Application No: AB/135/20/OUT
Site Address: Land at Ford Road Arundel
Description of works: Outline application with some matters reserved (except for access) for the development of 90 dwellings & associated amenity land. This application is a Departure from the Development Plan, affects the setting of listed buildings & affects the character & appearance of the Arundel Conservation Area.

Thank you for your internet representation made on 28th January 2021 which has been recorded as an objection with the comments as follows:

Parameter Plan - Movement

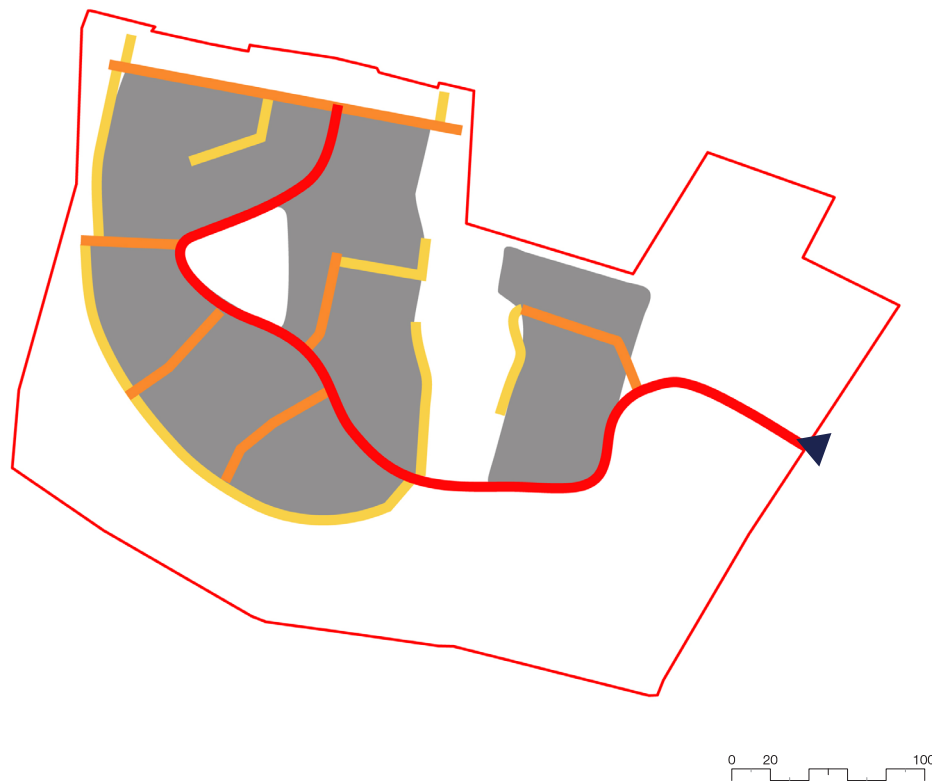
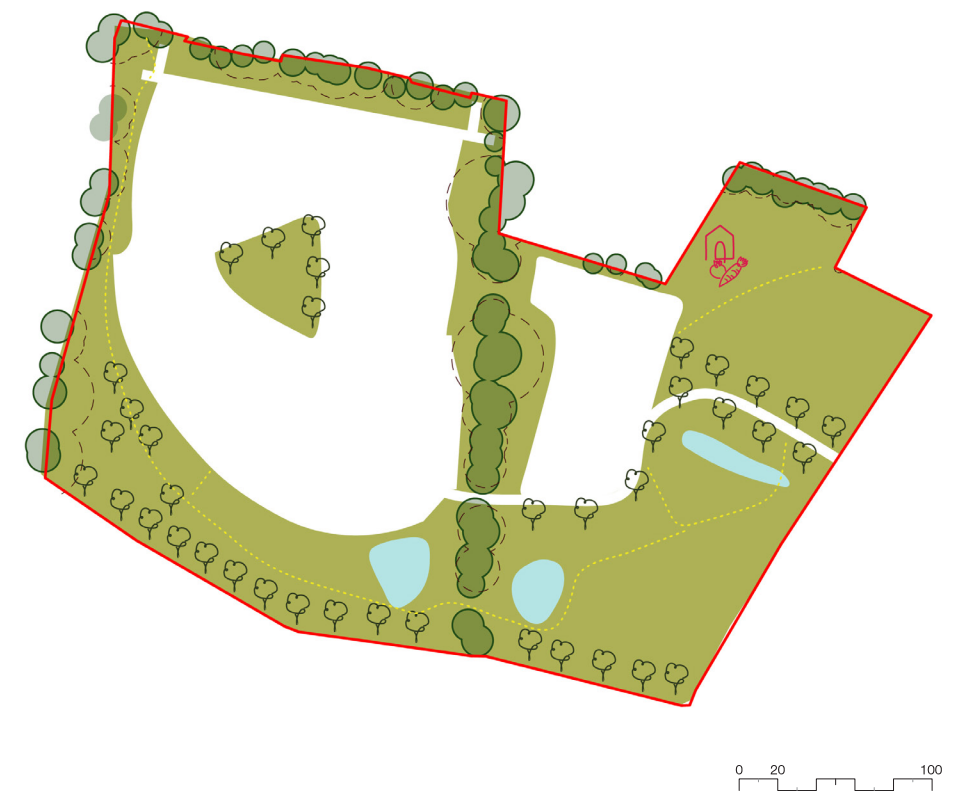
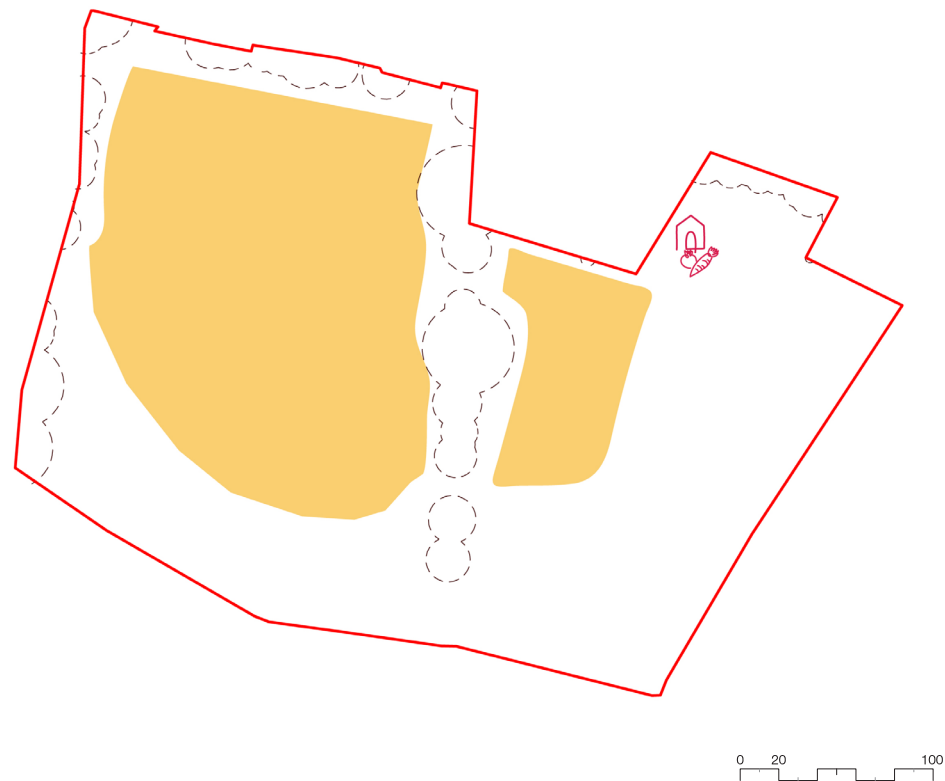
The original plans showed Dalloway Road as being an emergency access route. Now it shows two additional access routes into the site. It is not clear from the drawings what these access points will be. The legend on the drawings is not clear at all. (High Ridge and Dalloway Road). If it is pedestrian, why does the plan show roadway leading up to both access points? This will only change the nature of the surrounding roads that are currently quiet and calm.
